From: Lewis, Trevor [mailto:Trevor.Lewis@lancashire.gov.uk]
Sent: 05 June 2013 11:24
To: Colin Sharpe
Cc: planning; ENV LHS Customer Service
Subject: 3/2013/0394 The Moorcock Inn.

Title: Proposed site plan & landscaping details

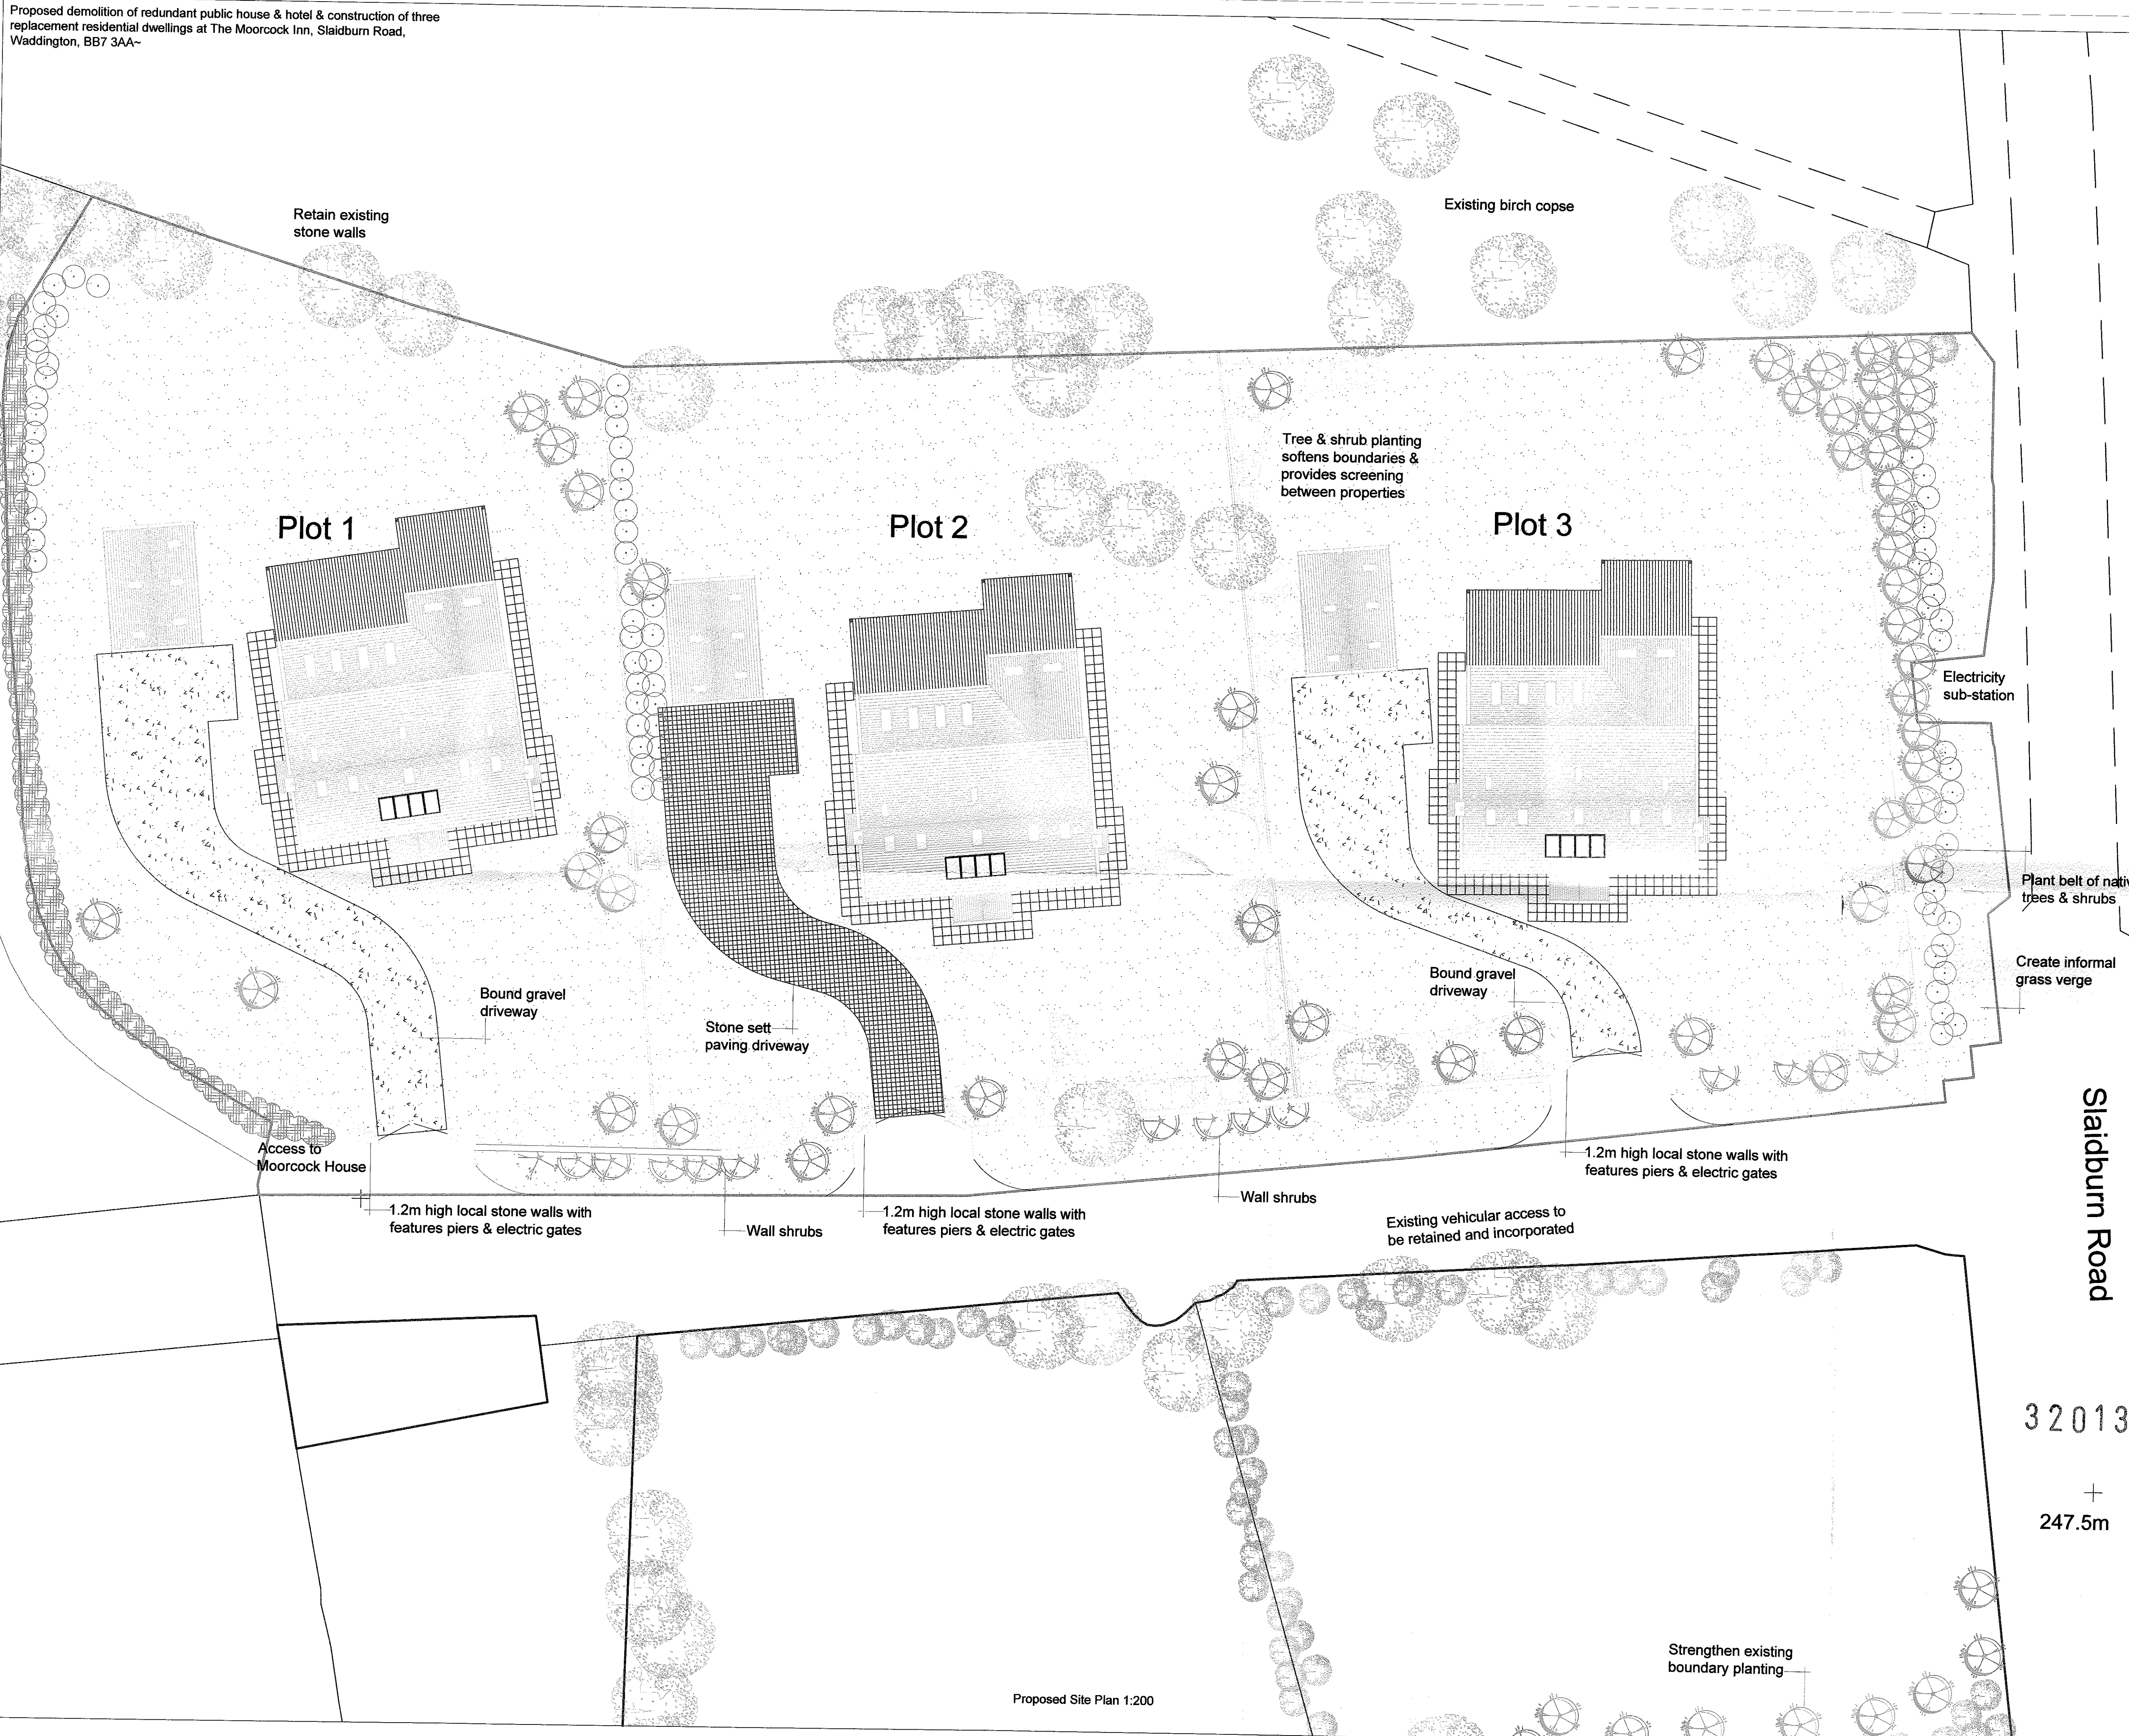
The existing minor access on to Slaidburn Road at the northern end of the site shall be physically and permanently closed and the existing vehicular crossing shall be reinstated to a verge in accordance with the Lancashire County Council Specification for Construction of Estate Roads (prior to first occupation of the development) Reason: To limit the number of access points to, and to maintain the proper construction of the highway.
